17 September 2025

Council Response to SSD-81434988- Alspec Warehousing Facility at 221-235 Luddenham Road, Orchard Hills, NSW, 2748

GENERAL ARRANGEMENT PLAN

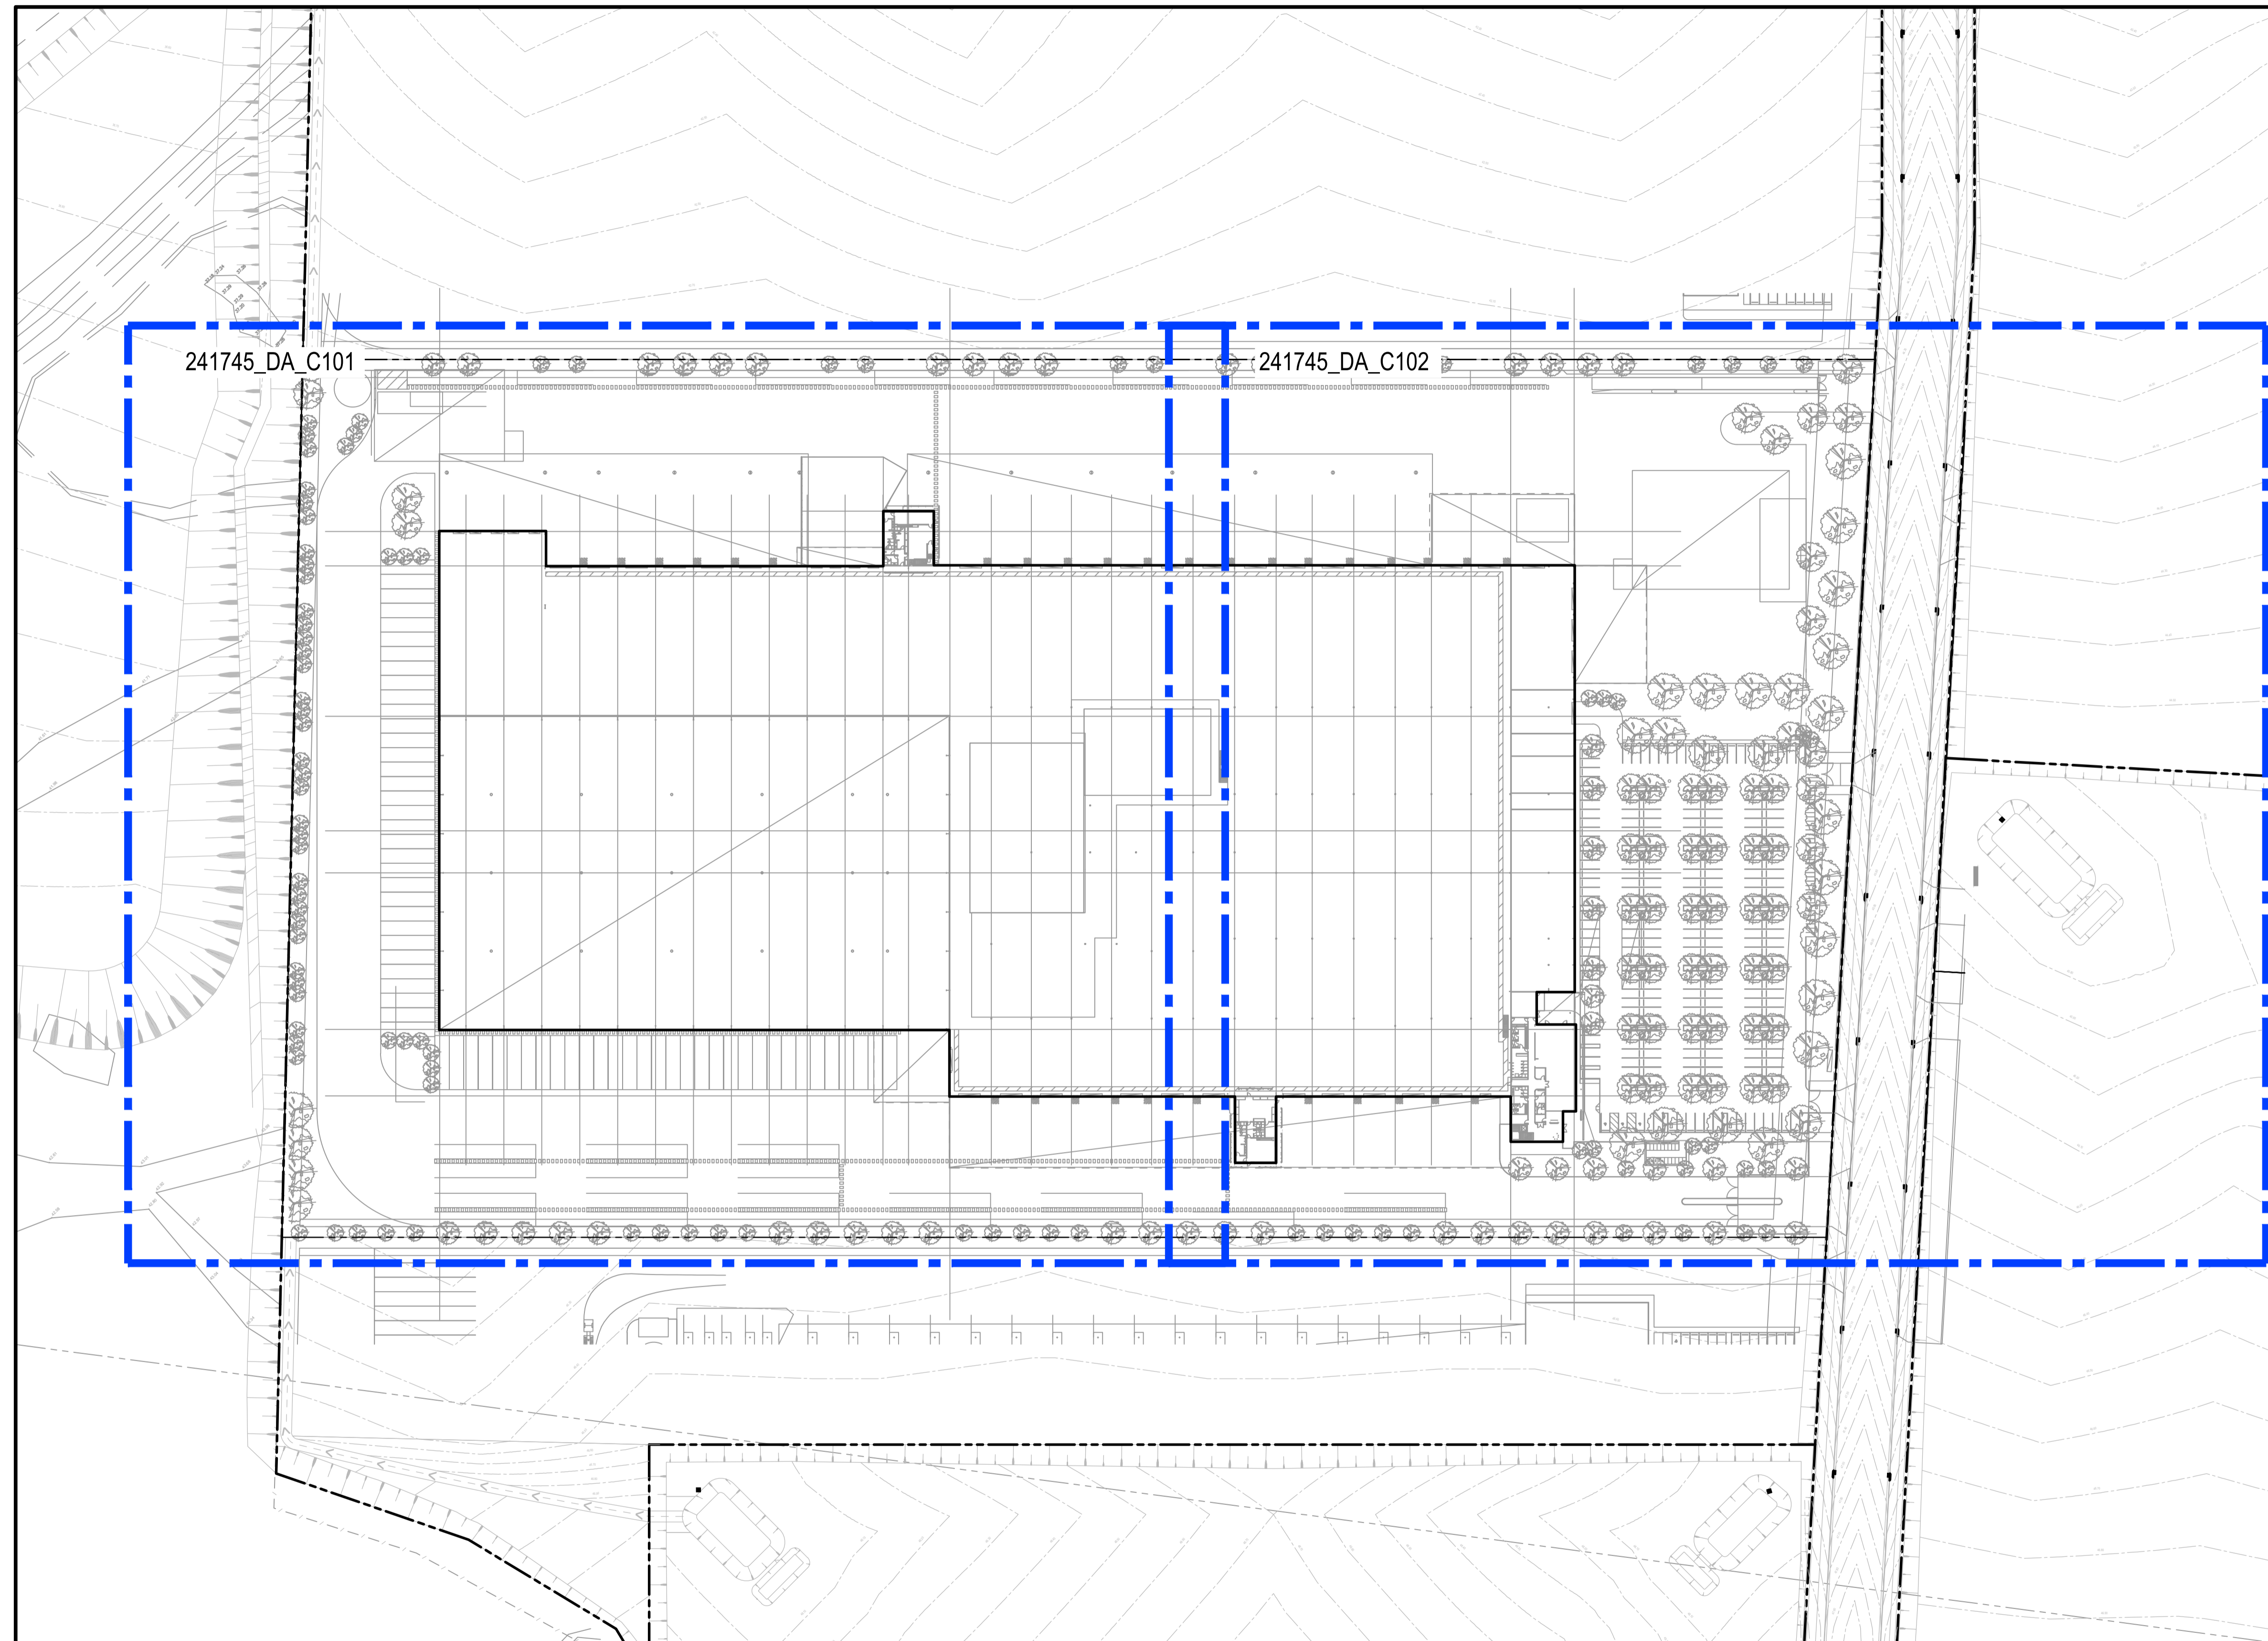
- a) The egress of heavy vehicles is designed in manner that two trucks could potentially be leave simultaneously creating conflict as they cross each other's travel path during the manoeuvre on to the public road. It is recommended that the weighbridge is relocated further west within the site to allow space for the formation of a single travel lane at the exit driveway.
- b) S138 Roads Act approval is to be obtained from the Roads Authority for any works within the public road reserve. Applicable bonds are to be paid to Council as required for the S138 Roads Act approval. A suitable condition to be provided accordingly.
- c) A suitable condition is to be provided for the delivery of external road works are per the VPA prior to the issue of the first OC. This has been mentioned previously in this letter.

- b) The civil plans are not of sufficient detail (dimensions not provided for assessment purposes) to assess whether compliance with AS2890.2 has been demonstrated regarding any proposed truck entry/exit driveways and heavy vehicle parking and with AS2890.1 in regard to car parking areas. The Department should review this component to ensure suitable vehicle movements and parking can be achieved.

- c) Any internal driveway access gates/boom-gates/etc. must be positioned internally such that a full vehicle length (of the largest vehicle designated to use the corresponding entrance) can be accommodated wholly within the site and not queue on the public roadway. It is not clear from the application whether this has been achieved.

Figure 5-2 Waste vehicle path of travel through the site

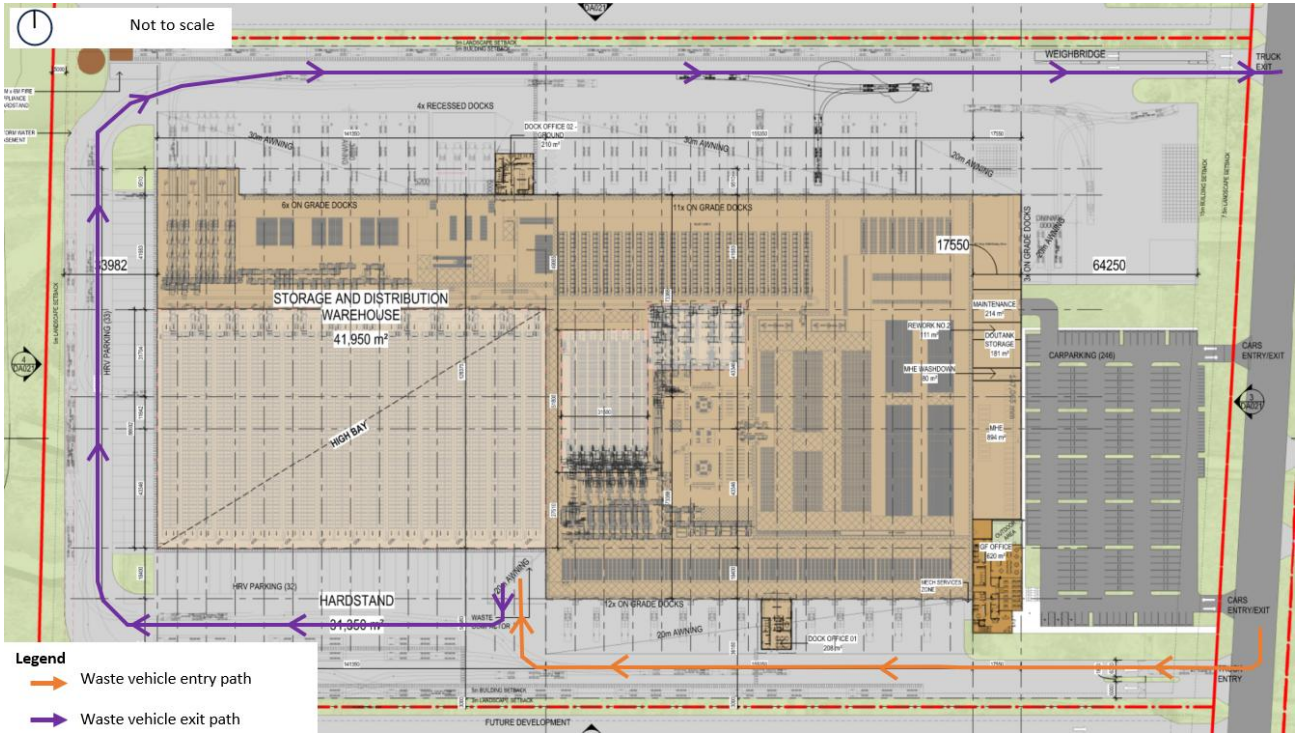
- a) The facility is expected to utilize Roll-On Roll-Off (RORO) bins for waste collection. It is recommended that the Department request detailed section plans to demonstrate that the required height clearances are afforded for the safe and efficient collection of these bins. This includes clearances for both the RORO vehicles and the bins during loading and unloading operations. Ensuring proper clearances will mitigate the risk of damage to property and equipment.

Figure 4-2 Indicative construction parking area

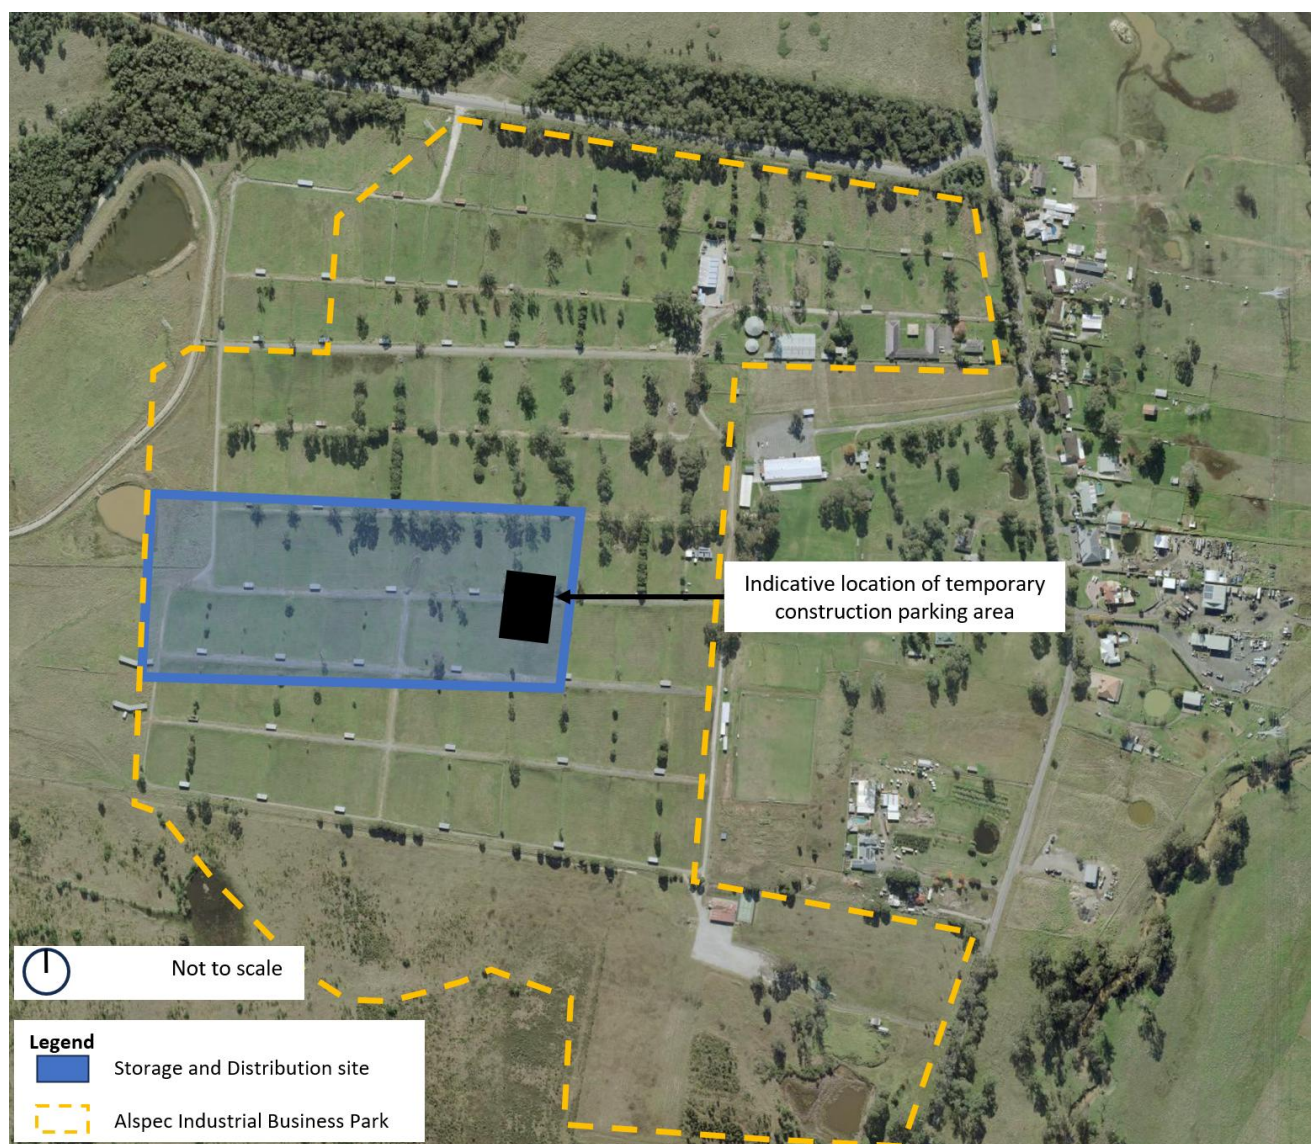
- d) The Department should seek clarification for the Traffic Management Plan noting provision of construction parking spaces and access to the development location.
